December 7, 2012

**Re: Atrisco Apartments, 1720 Atrisco Dr NW, Traffic Circulation Layout
Architect's Stamp dated 11-27-12 (H11-D068)**

Kristal D. Metro, P.E.
Traffic Engineer, Planning Dept.
Development and Building Services

1 TCL - Traffic Circulation Layout Plan
1" = 20'-0"

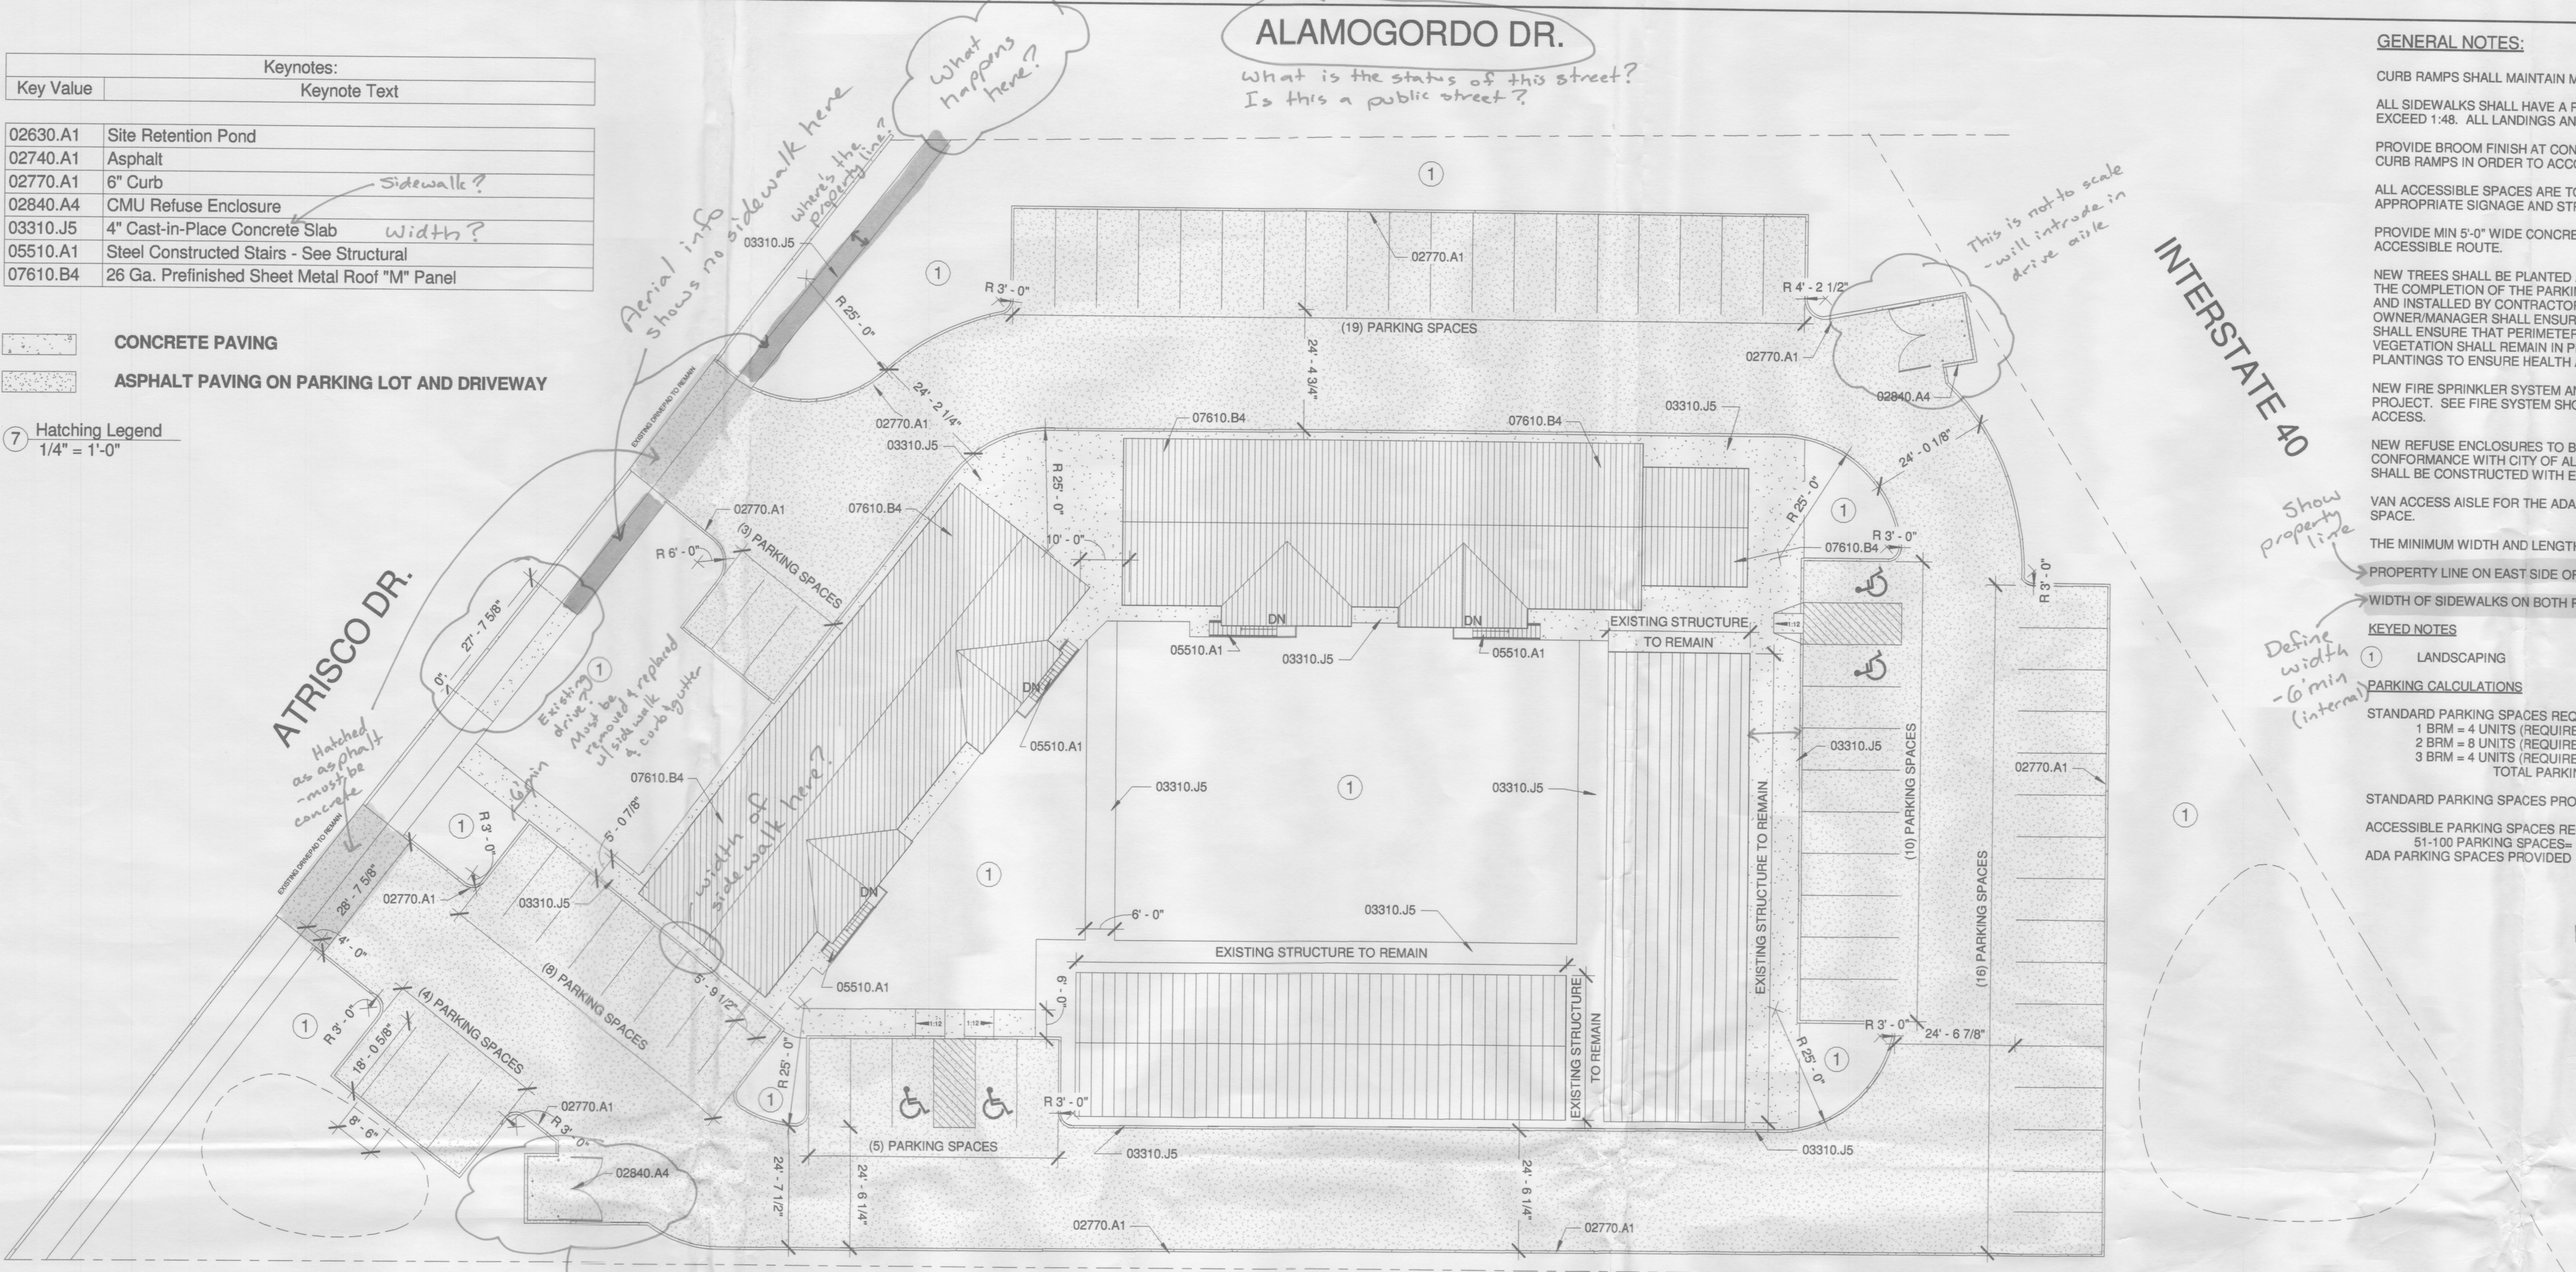
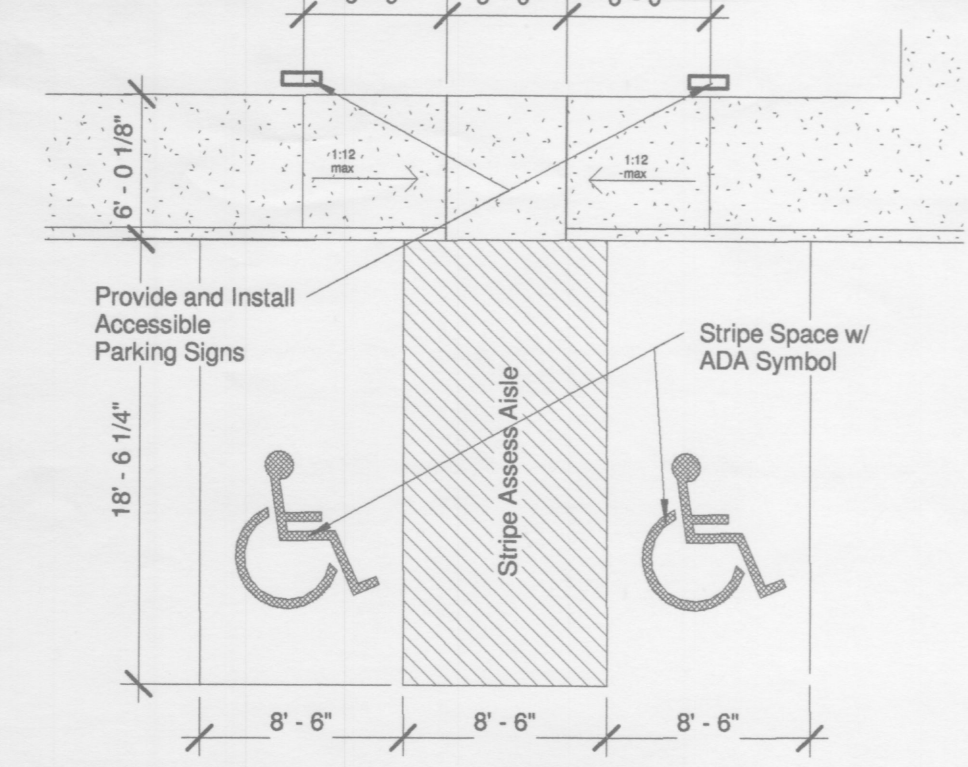
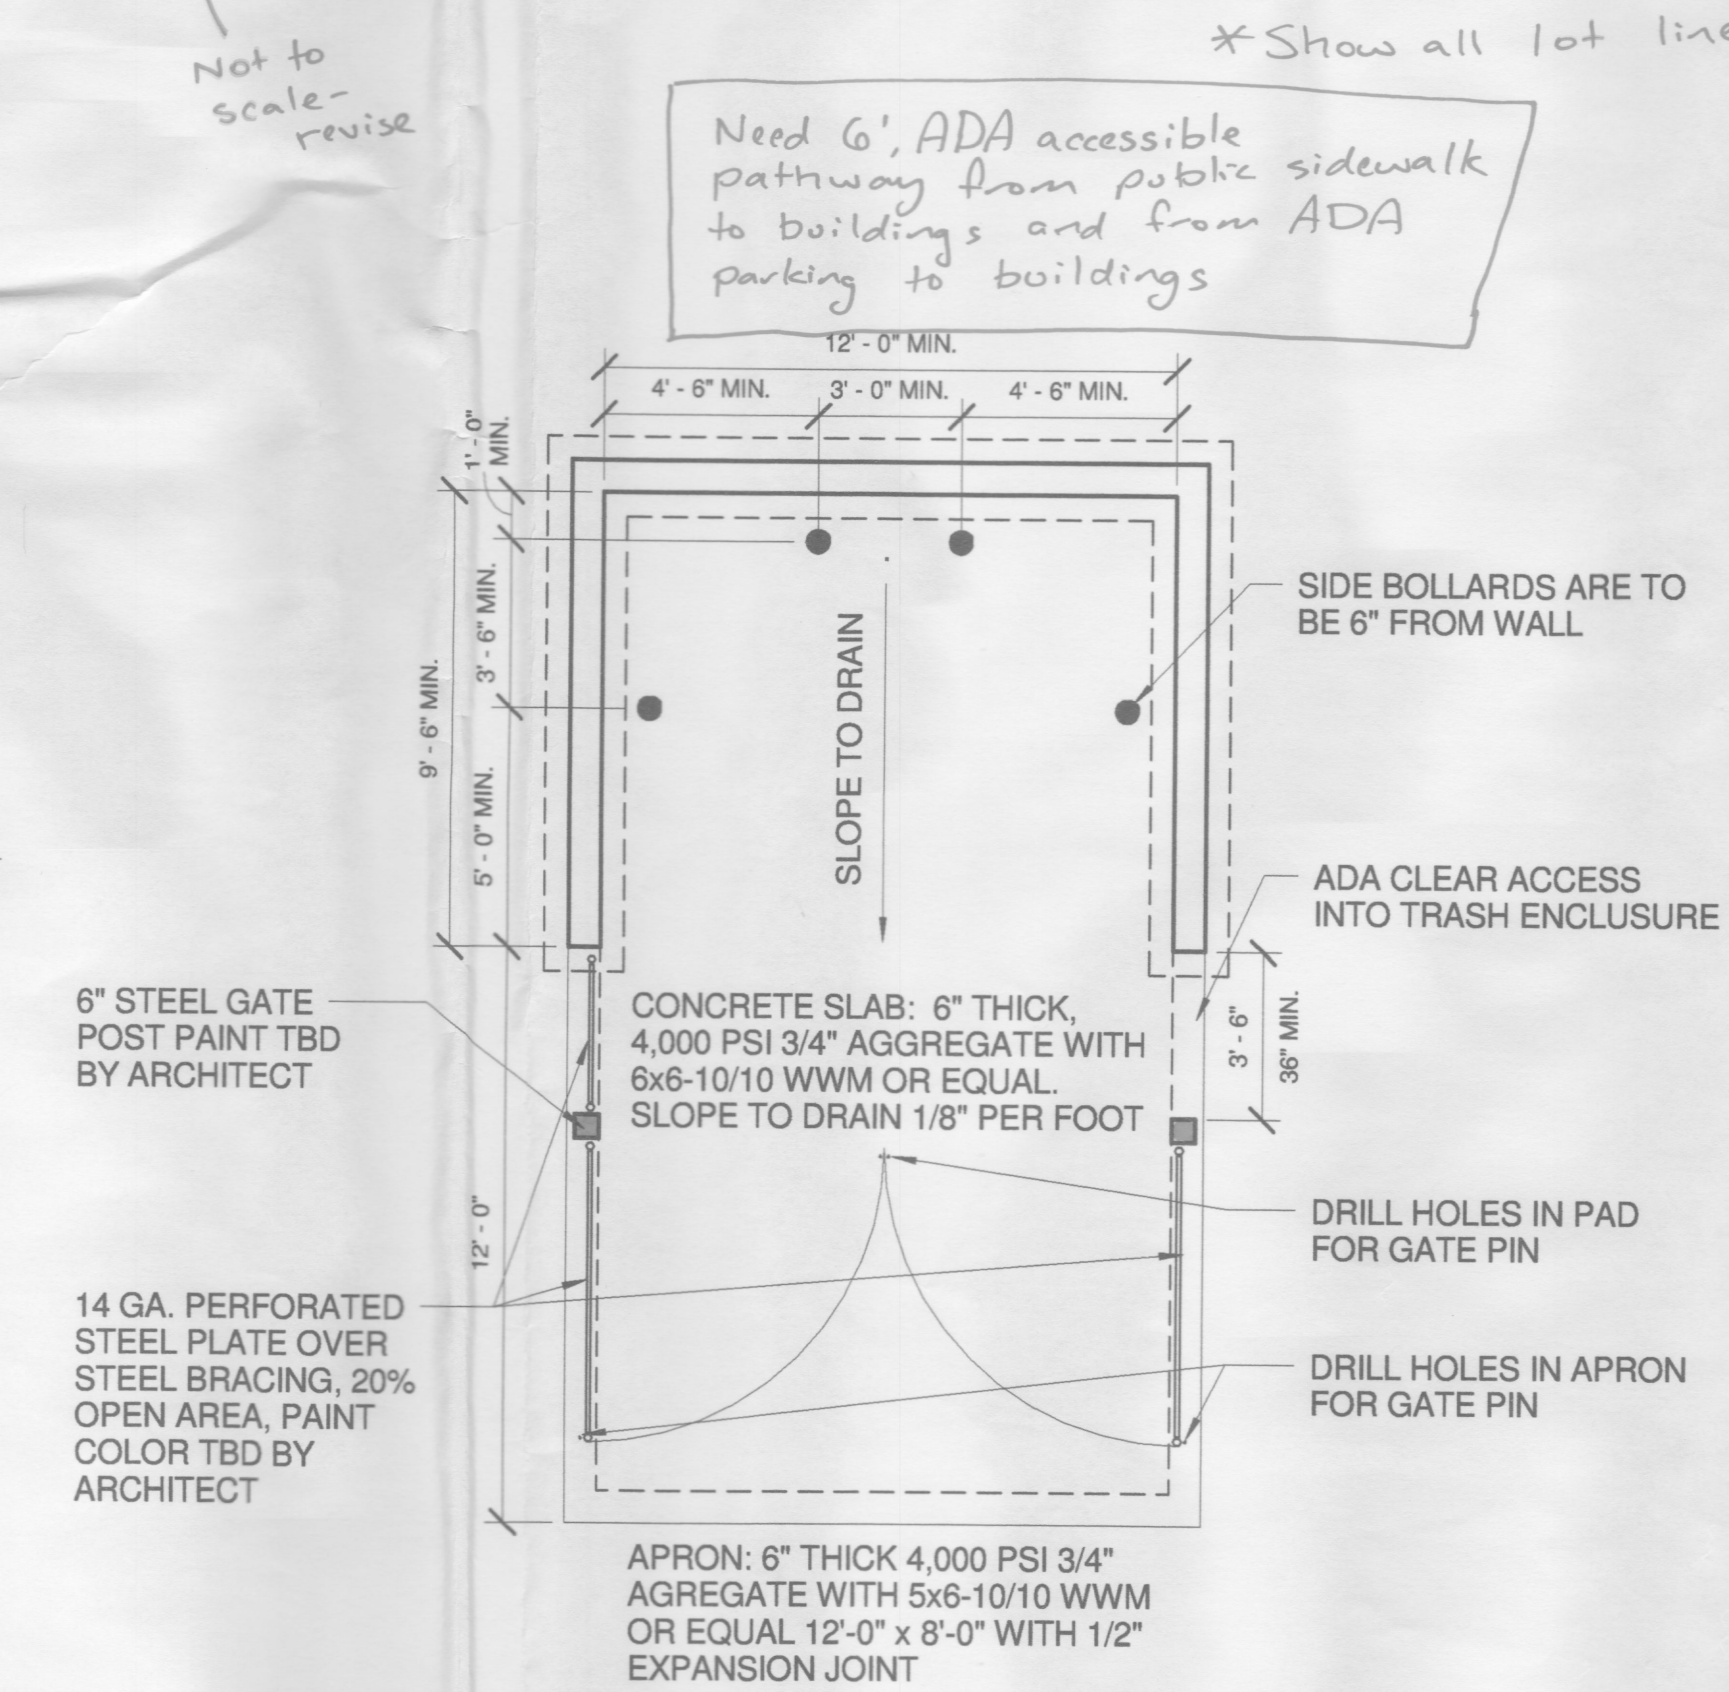
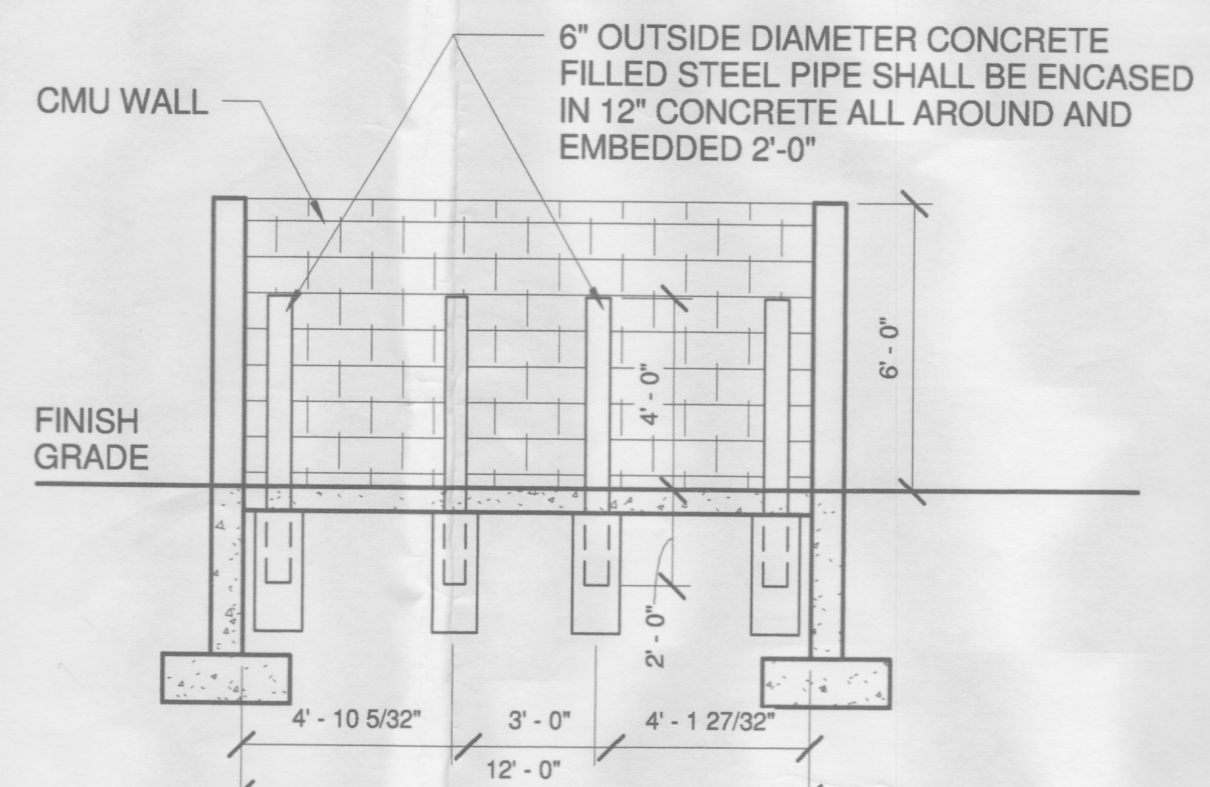
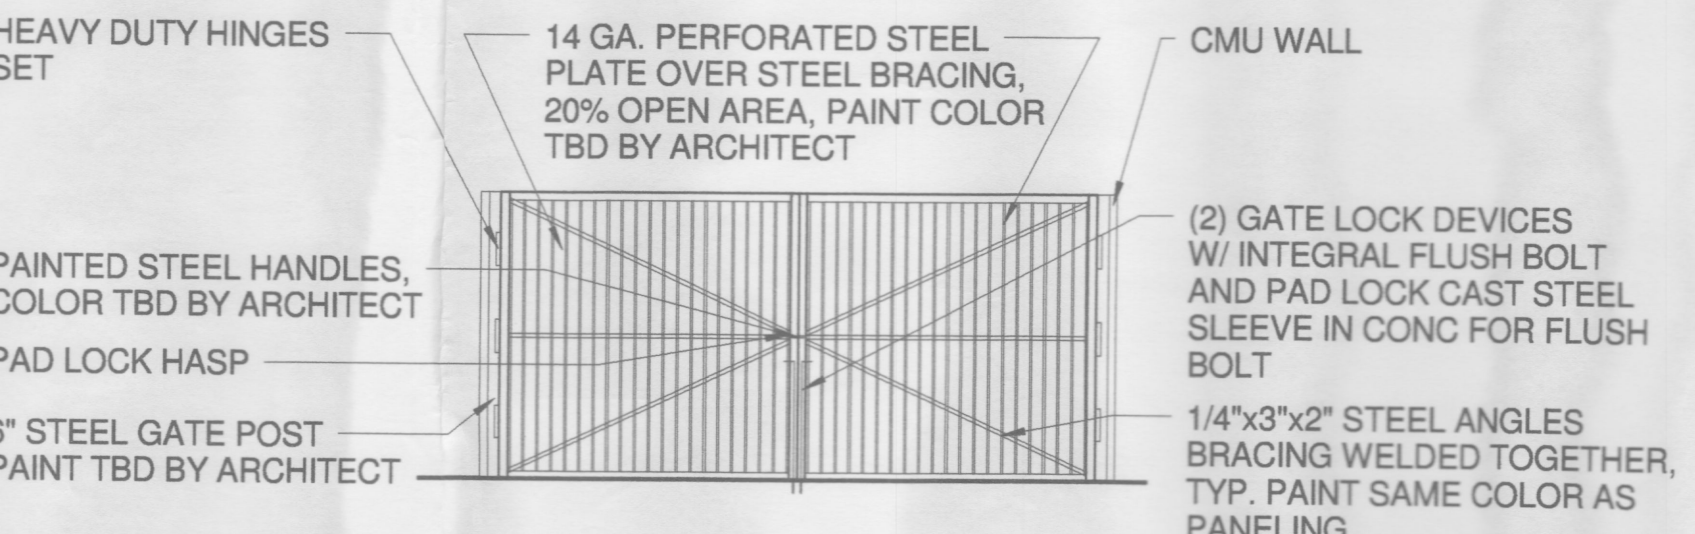
1. Clearly show existing versus proposed conditions. The current TCL submitted is unclear. For example: indicate limits and widths of existing sidewalk to remain, limits and widths of proposed sidewalks, existing driveway to be removed and replaced with sidewalk/curb & gutter and existing asphalt and proposed asphalt. The hatching type indicating concrete and asphalt does not clarify between proposed and existing. For example, the existing driveway and abutting sidewalks are hatched "asphalt." City of Albuquerque Standards require that these items be concrete.

2. Define the width of all sidewalk, existing and proposed.
3. Is the entire parking area going to be repaved?
4. Is there existing sidewalk along the full length of the Atrisco frontage? According to aerial view, there is no sidewalk to the north of existing driveway. Please Clarify.

5. Provide build notes, referring to the appropriate City Of Albuquerque Standard Drawings (COA std. dwgs) for all proposed infrastructure in the City right of way (ROW) (curb cuts, sidewalk, etc.).

6. Per the *Development Process Manual*, Chapter 23, Section 6, Part B.17, "Any driveways that are abandoned must be replaced with sidewalk, curb and gutter by the property owner." Please indicate driveway to be removed and reference COA std. dwgs for proposed infrastructure to replace driveway (for example: replace with Standard Curb & Gutter per COA dwg #2415A and 4' wide Sidewalk per COA dwg#2430).

7. Clarify existing conditions along Alamogordo Drive. The emails included with this submittal are unclear; is Alamogordo Drive being vacated?
8. Clearly show the property line along all frontages. The general note provided that references a property line along Atrisco Dr is unclear. Does the property line along Atrisco Dr. frontage lie along the inside edge of the COA ROW sidewalk? If the public sidewalk is currently located outside City of Albuquerque right of way, a public sidewalk easement will be required. Please clarify location of property line.

9. The trash enclosures are not drawn to scale in the TCL layout. The northern trash enclosure appears to reduce the drive aisle to approximately 19-20 feet when drawn to scale. Two-directional traffic requires a minimum 24-foot wide aisle width. Please provide a layout to scale and provide drive aisle widths.

10. Recent GIS information indicates that this site consists of 5 or 6 lots. Show all lot lines on the plan. Will this site be replatted? If not, cross access easements are required.
